KITTITAS COUNTY FIRE MARSHAL'S OFFICE

June 20, 2016

Re: Wallace (BL-16-00006)

**PART OF THE NORTHEAST QUARTER OF SECTION 31,
TOWNSHIP 17 NORTH, RANGE 19 EAST, W.M.**

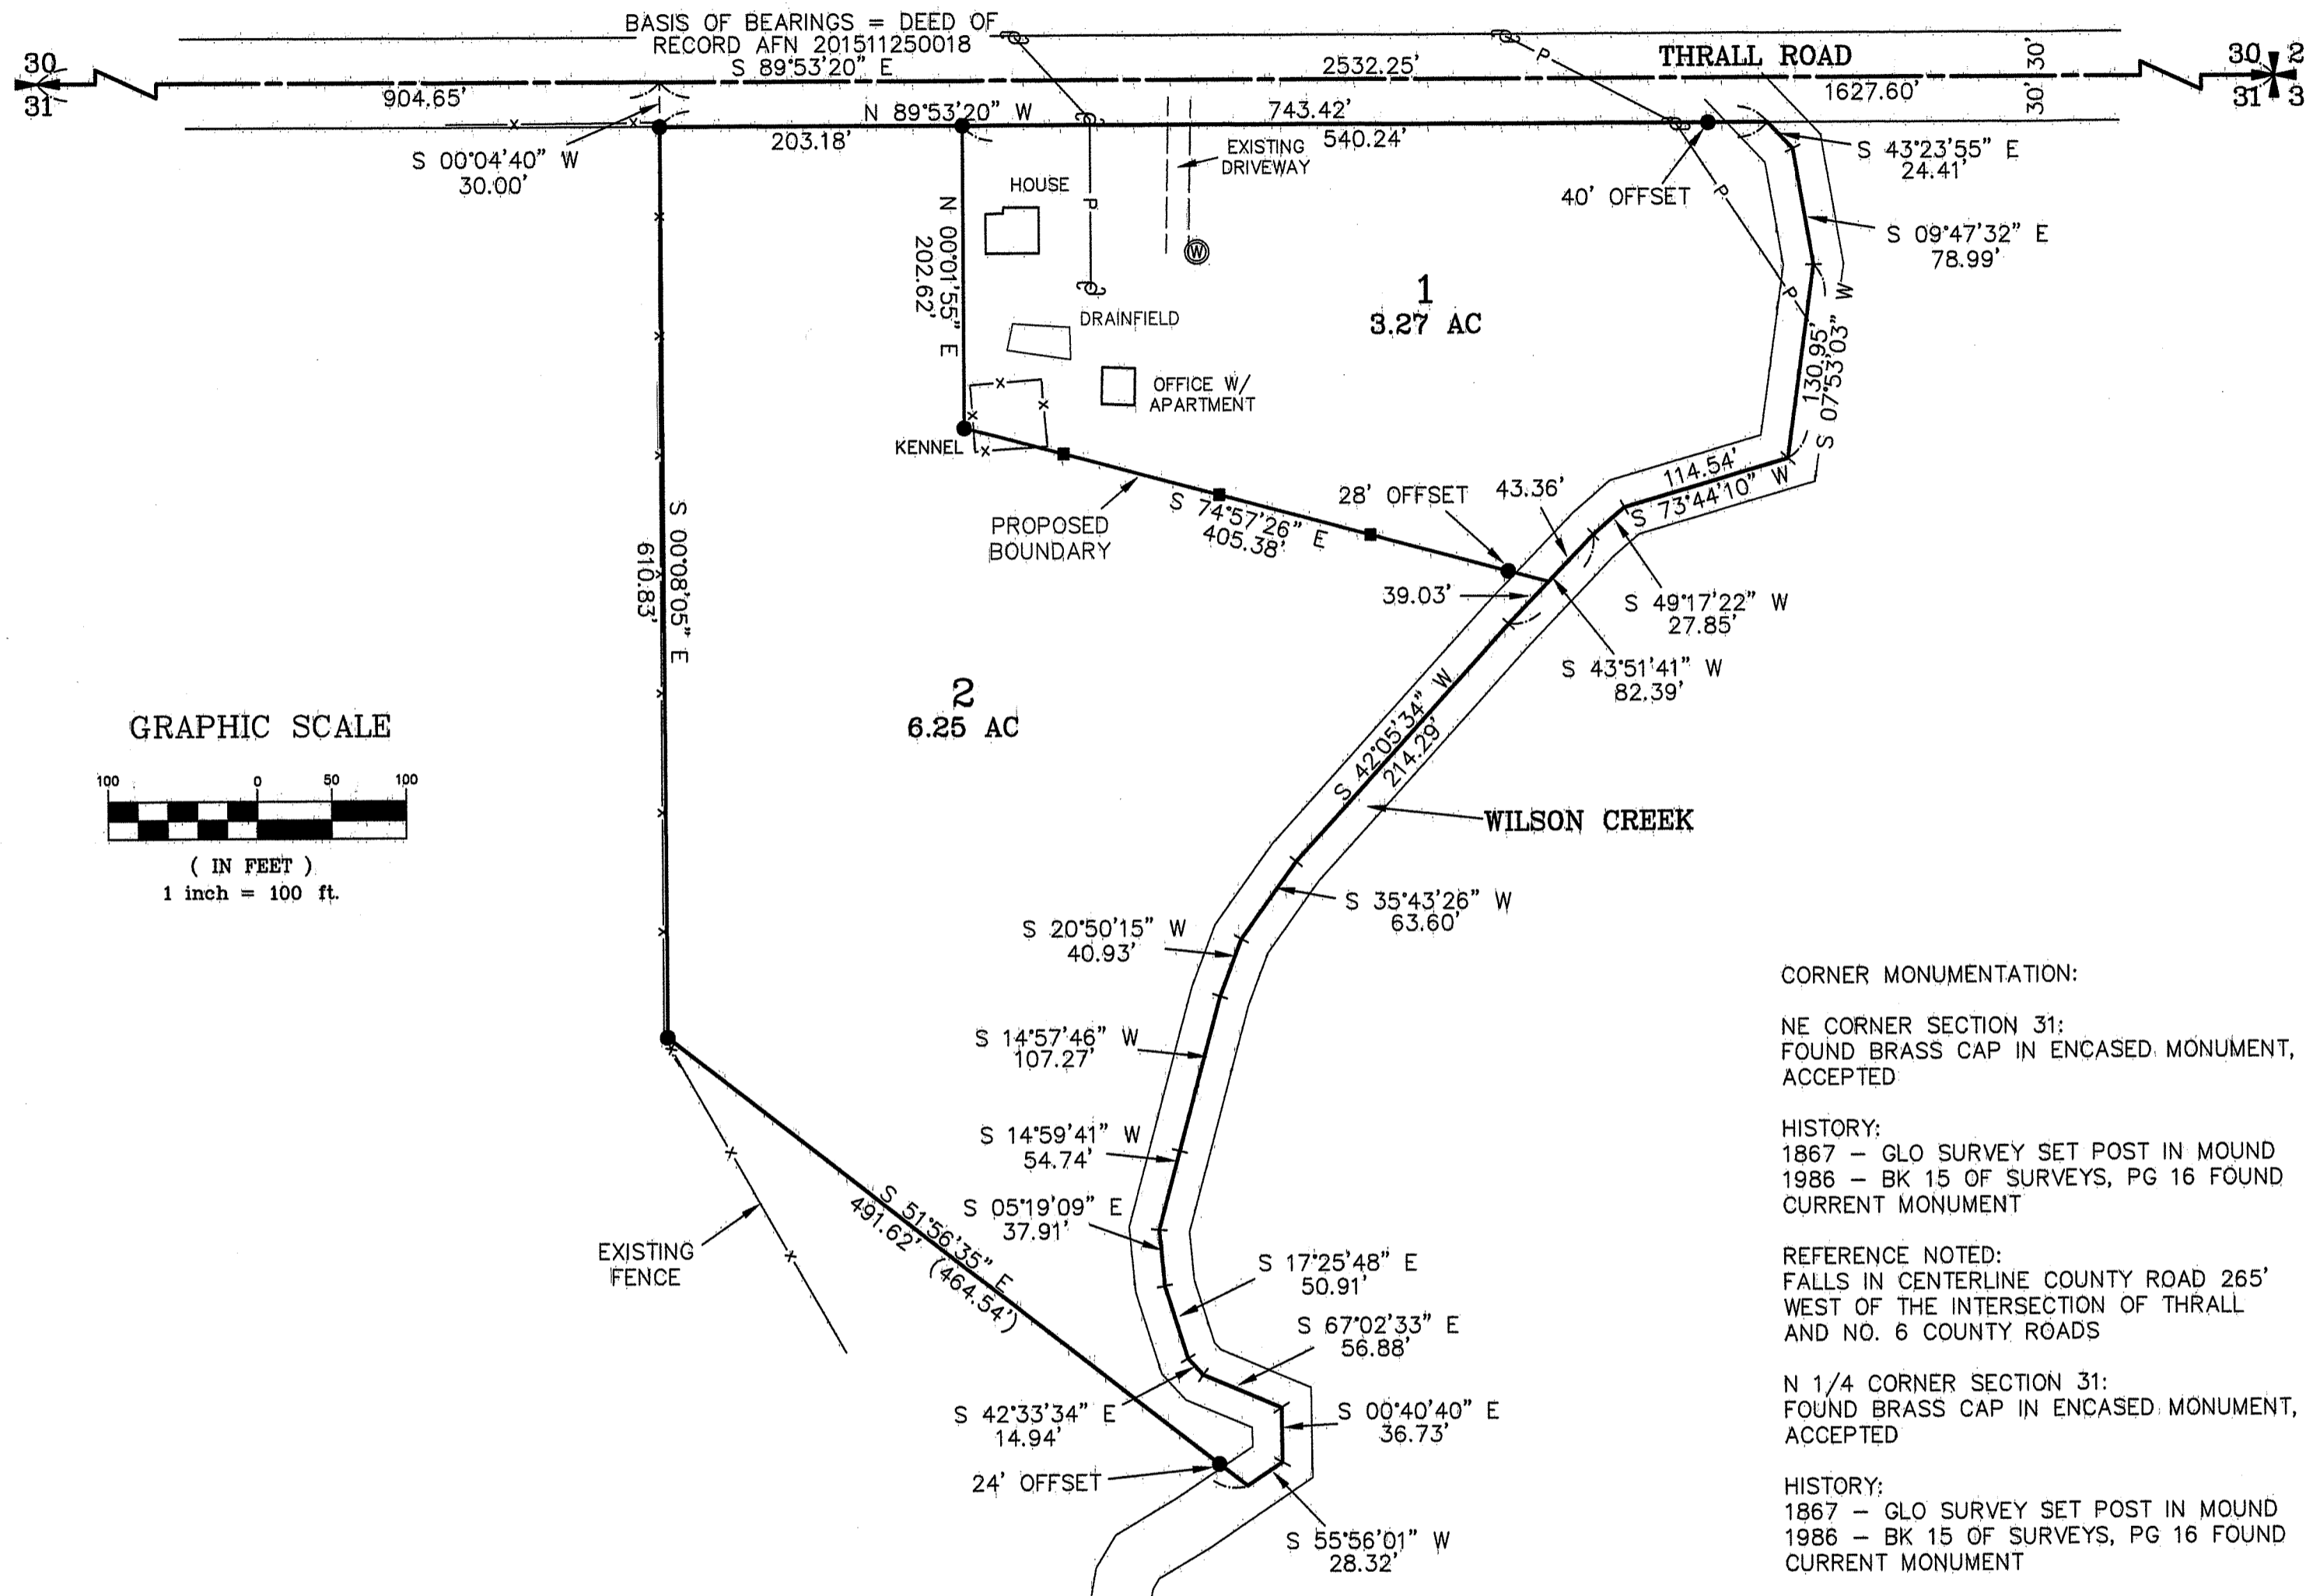
- Ensure that boundary line adjustments do not infringe upon existing structures, to include propane tanks, etc.
- Ensure adequate access for fire apparatus. Any driveways or access points created based off the new lot configurations shall comply with Kittitas County Code 20.02.030.
- All future development must comply with the International Fire Code.
